Please ask for: Nicola Moore
Email: nicola.moore@arun.gov.uk
Telephone: Ext 37944
Our Ref: AL/12/21/CLP
Your Ref:
Date: 5th February 2021

Lawful Development Certificate for a Proposed Use or Development

Development: replace existing garden room/outbuilding
Location: Thatched Cottage Arundel Road Norton PO18 0JX

THATCHED COTTAGE ARUNDEL RD WORTON. PO18 0JX

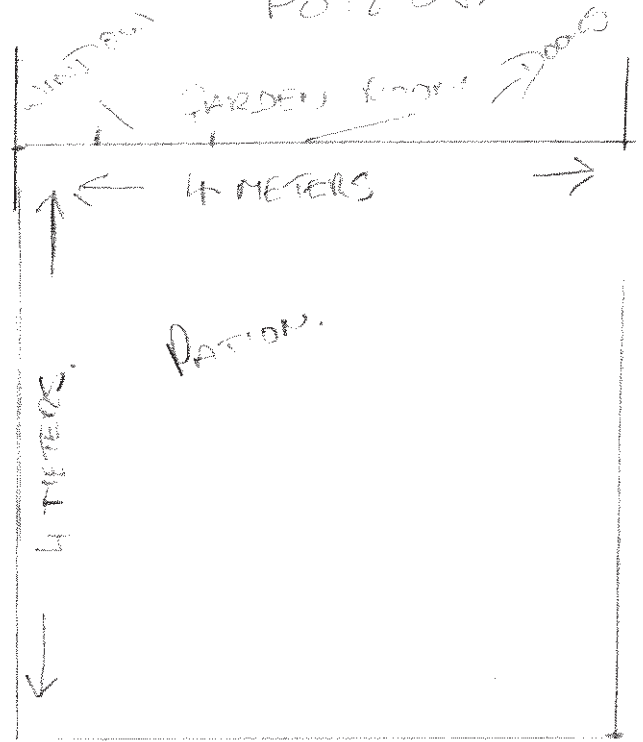
Please amend the Proposed Floor Plan to include measurements of any windows and doors.
